16.01.2024
4875/3.1

MR & MRS BASSI:1A BOTWELL CRESCENT, HAYES

Planning ref: 72105/APP/2023/3332

SITE PLAN
GROUND FLOOR

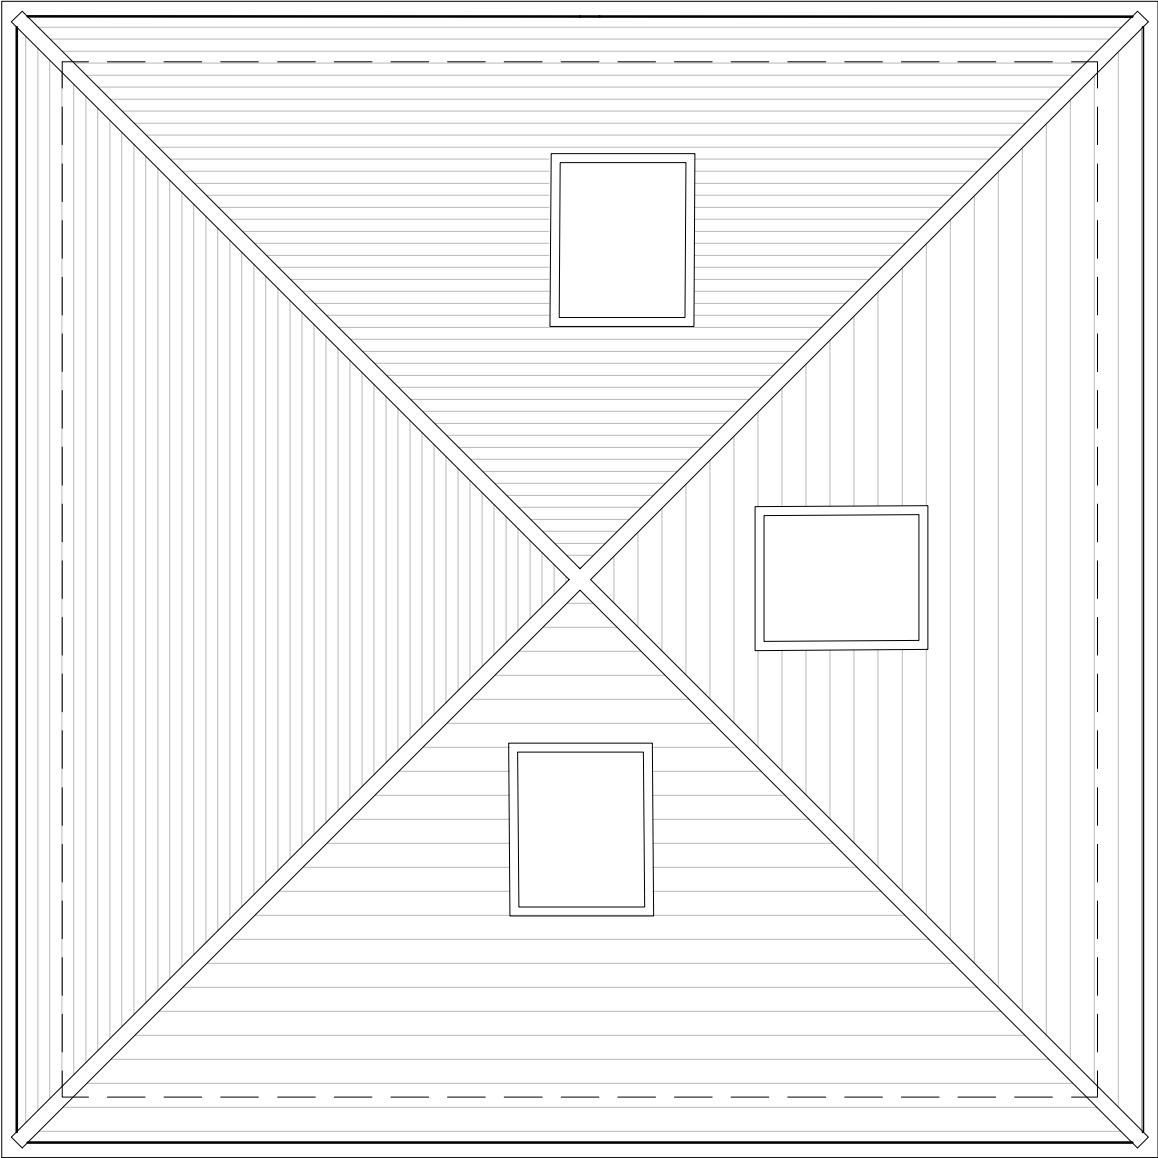
Thank you for the comments from the Highways Department. We have now updated our site plan to show the required 2.4m vision splay. The fencing and hedge have been removed up to the 2.4m.
